Our Ref: LU/339/18/HH
Your Ref:

Town & Country Planning Act 1990 (as amended)
Town & country Planning (Development Management Procedure) (England) Order 2015
Application for Planning Permission for Works or Extension to a Dwelling

Development Two storey side extension and rear extension
Location 1 Steele Crescent Wick Littlehampton

Drawing Title:	Site & Location Plans	
----------------	-----------------------	--

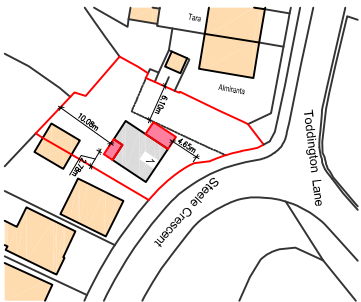
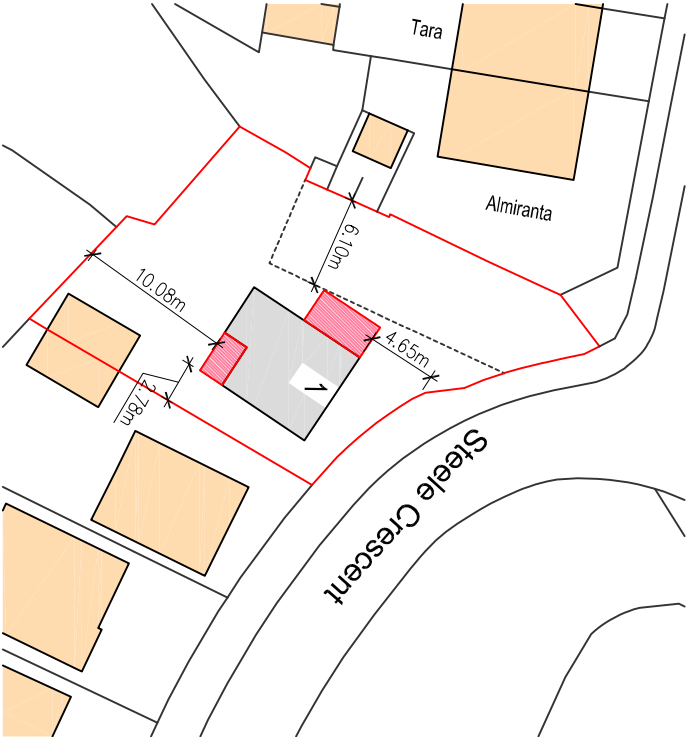
Block Plan

Please submit 1 electronic or 3 paper copies of a block/site plan which has all the dimensions from the proposed extension(s) to the site boundaries at a scale of 1:500 or 1:200. Further details of what must be included on the plan can be found in the National Validation Requirements.

Confirmation Required: You have included the land at the side of the house in your location plan. Our GIS suggests its a electrical substation. Please confirm whether you own this land. If you do not own that land please remove it from within the red outline on the location plan.
